City of Portland, Maine - Building or Use Permit Application

Permit No: 10-0357		Issue Date:		CBL: 034 D003001	
Location of Construction: 163 Preble St		Owner Name: City Of Portland		Owner Address: 389 Congress St	
Business Name:		Contractor Name:		Contractor Address:	
Lessee/Buyer's Name		Phone:		Permit Type: Signs - Temporary	
Past Use: Commercial / Govermental		Proposed Use: Commercial / Erect 4' x 6' freestanding sign.		Permit Fee:	
				Cost of Work: \$0.00	
				CEO District: 1	
Proposed Project Description: Erect 4' x 6' freestanding sign.		FIRE DEPT: <input type="checkbox"/> Approved <input type="checkbox"/> Denied		INSPECTION: Use Group: Type:	
		Signature:		Signature:	
		PEDESTRIAN ACTIVITIES DISTRICT (P.A.D.)			
		Action: <input type="checkbox"/> Approved <input type="checkbox"/> Approved w/Conditions <input type="checkbox"/> Denied			
		Signature: Date:			
Permit Taken By: gg		Date Applied For: 04/12/2010		Zoning Approval

Location of Construction: 163 Preble St	Owner Name: City Of Portland	Owner Address: 389 Congress St	Phone:
Business Name:	Contractor Name:	Contractor Address:	Phone
Lessee/Buyer's Name	Phone:	Permit Type: Signs - Temporary	Zone:

Elm Street Location

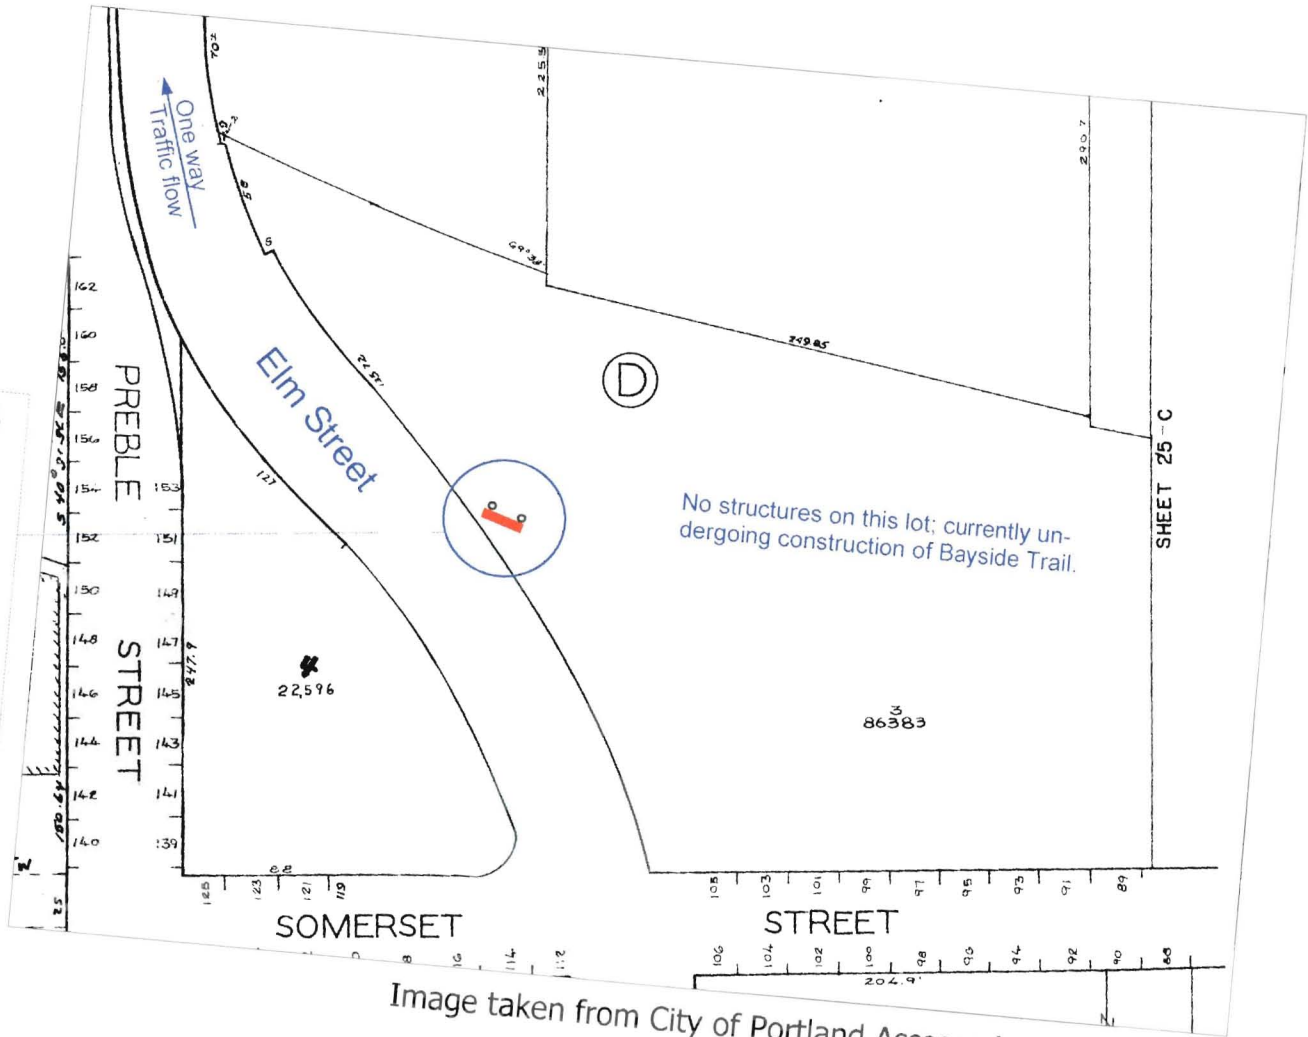
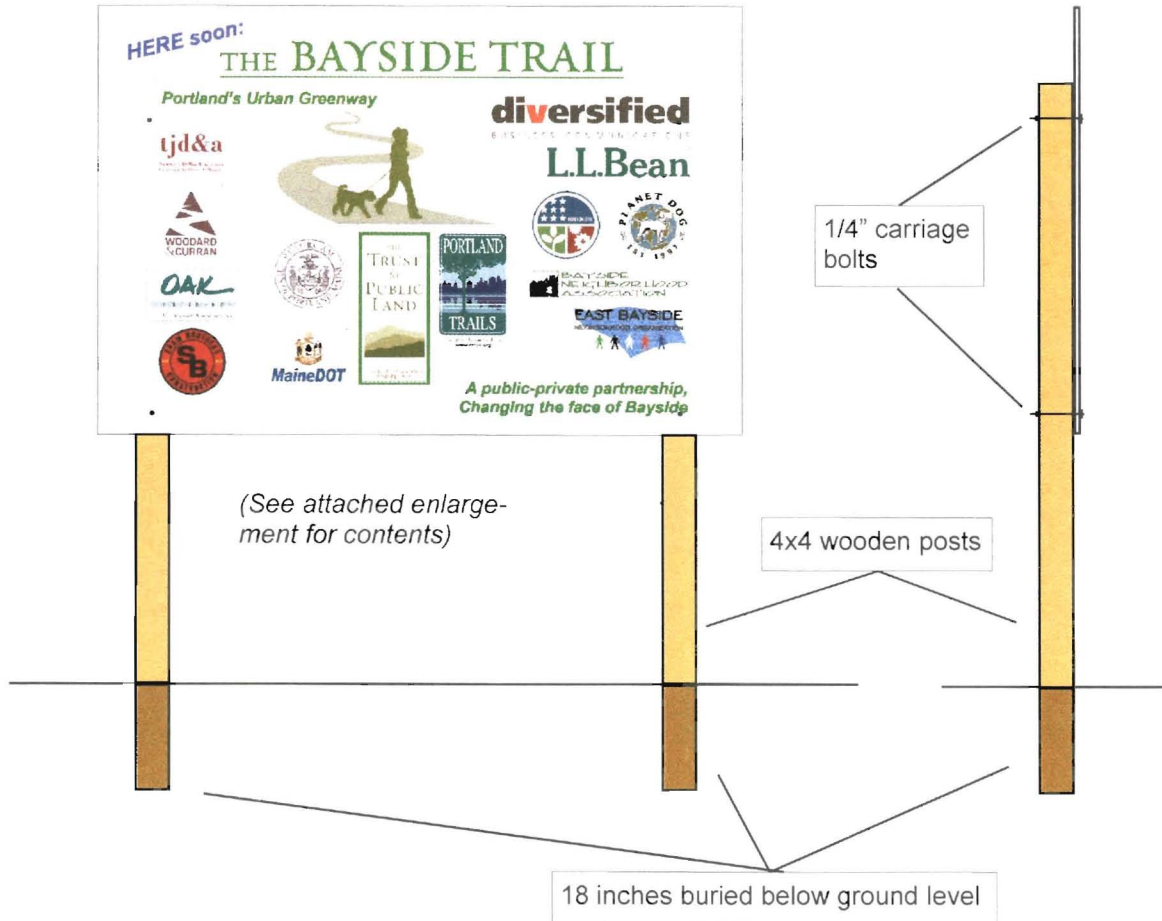
- 1) The sign shall be erected for one year from the date of approval, after which time is shall be removed.
- 2) The applicant shall obtain a license from the City of Portland for the freestanding sign.
- 3) The sign shall be setback five (5') feet from the edge of the existing sidewalk on Preble Street.

4/13/2010-mes: Is over the sign size for freestanding signs, needs a review under 14-368.5.g. Does this need insurance? Is a City Manager's license required on City land?
